Scheme: EWR2 Compound A1 Access

# Technical Audit

Reference: 272.13

Date: 20/1/20

Scale(s)	AS SHOWN	ELR - Project Chainage (Miles Yards)	XX - XXXXXXXX
Design Package Risk Classification	Normal	Sheet	1 of 1
Alternative Reference		Revision	B01
Drawing Number	133735_RW-EWR-XX-XX-DR-CH-000215

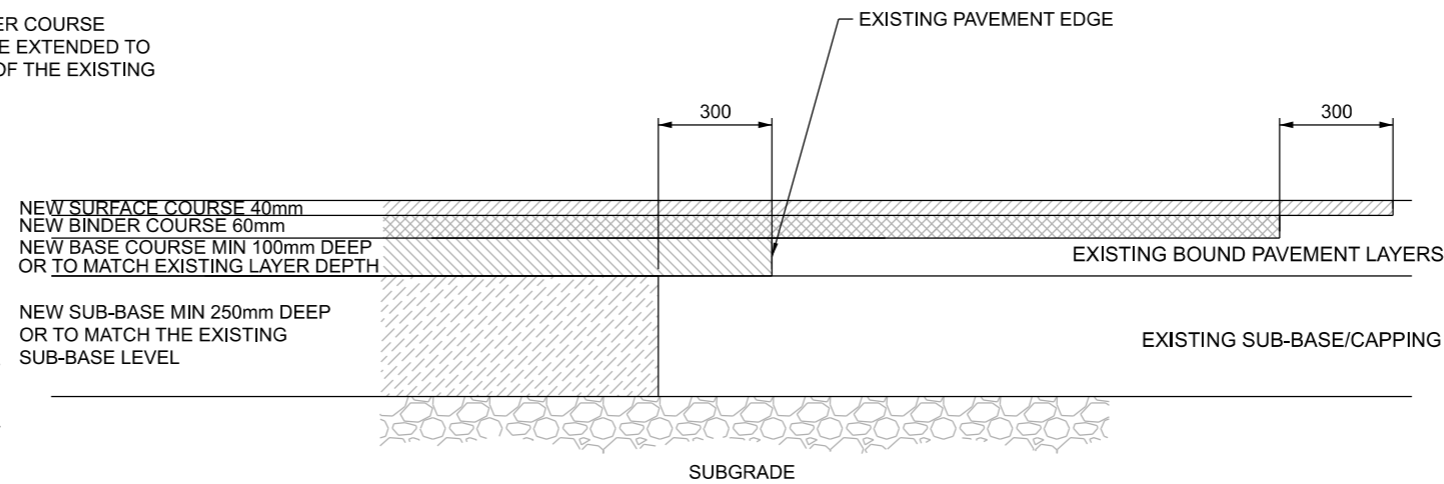
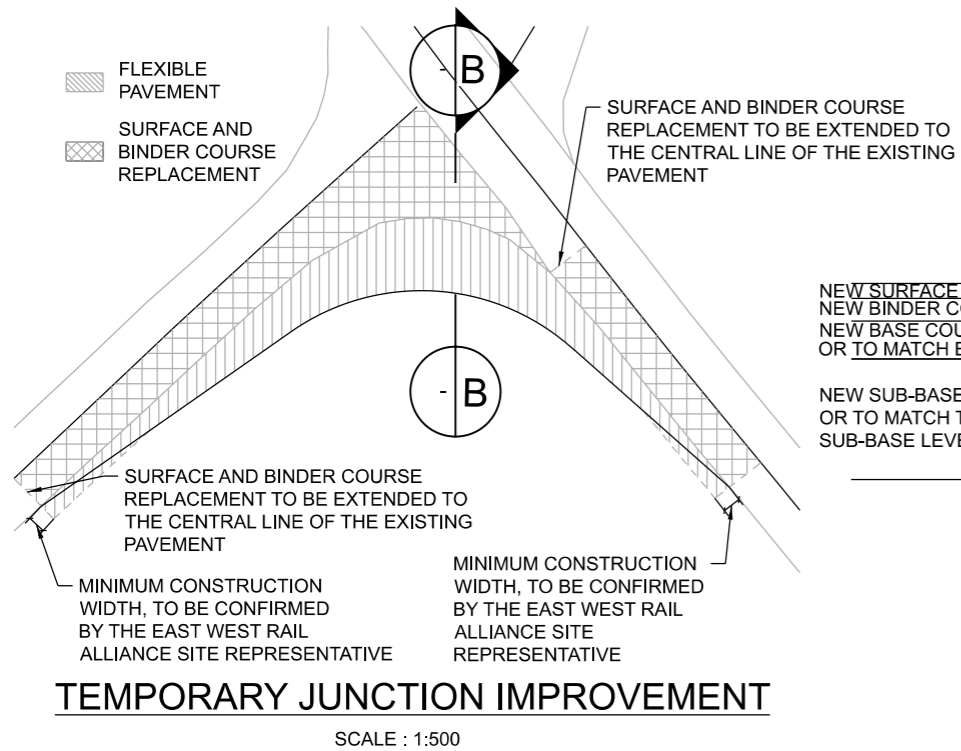
<ul style="list-style-type: none"> <li>2. Additional area of highway within the new access will mainly run into the site. Please show provision for discharging this run-off</li>   <li>3. Please show surfacing types and extents or include an additional drawing for these.</li>   <li>4. Access construction to be agreed – EWR2 want concrete within highway but OCC reluctant. TBC following detailed design from Atkins</li> </ul>	<p>decommissioned. The proposed temporary access road falls away from Bicester Road, so there will be no additional surface runoff entering the remaining existing gullies along Bicester Road.</p> <ul style="list-style-type: none"> <li>2. Drainage drawings 133735_RW-EWR-XX-A1-DR-DH-001101 to 001103 (included) show the proposed drainage system within the temporary compound. It should be noted that the section of the proposed temporary access road within the highway boundary will have over the edge drainage into the existing highway drainage ditch. The temporary access road outside highway boundary will have separate drainage system that will capture runoff and attenuate it to greenfield rates before outfall to a watercourse to the east of the proposed compound.</li>   <li>3. Pavement layout drawing 133735_2A-EWR-OXD-CC_A1-DR-CH-002019 is included and shows the types and extents of the proposed pavements.</li>   <li>4. Compound access construction is proposed as Type F5 Flexible construction shown on drawing 133735_RW-EWR-XX-XX-DR-CH-000215 which is included.</li> </ul>
